CITY OF ALBUQUERQUE

**Re: Starbucks at Independence Square
Erosion and Sediment Control Plan
Engineer's Stamp Date 12-27-16 (E17E076A)**

Based upon the information provided in your submittal received 3-18-16 the above referenced plan is approved to be included in the SWPPP and for ESC Permit for grading and Building Permit with the following conditions:

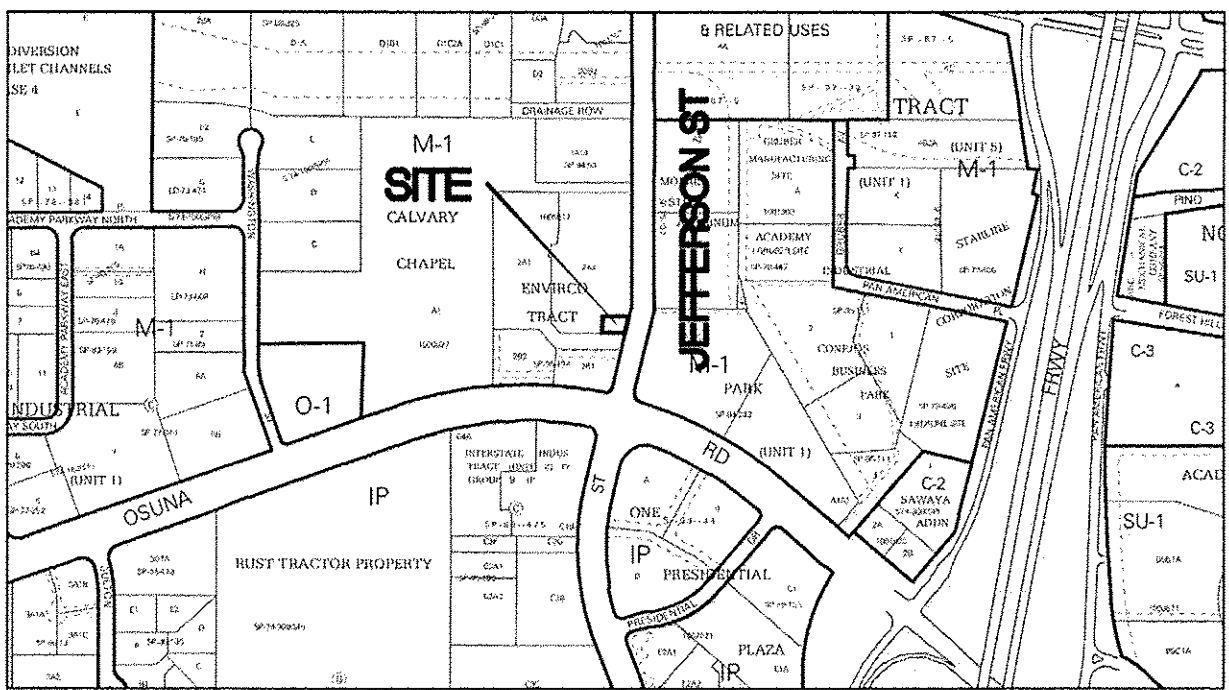
1. The silt fence should be replaced with a filter sock or straw wattle south of the building on the existing asphalt. Silt fence can't be buried in asphalt.
2. Place a filter sock at the downstream end of the channel that runs through the landscape area west of the building.
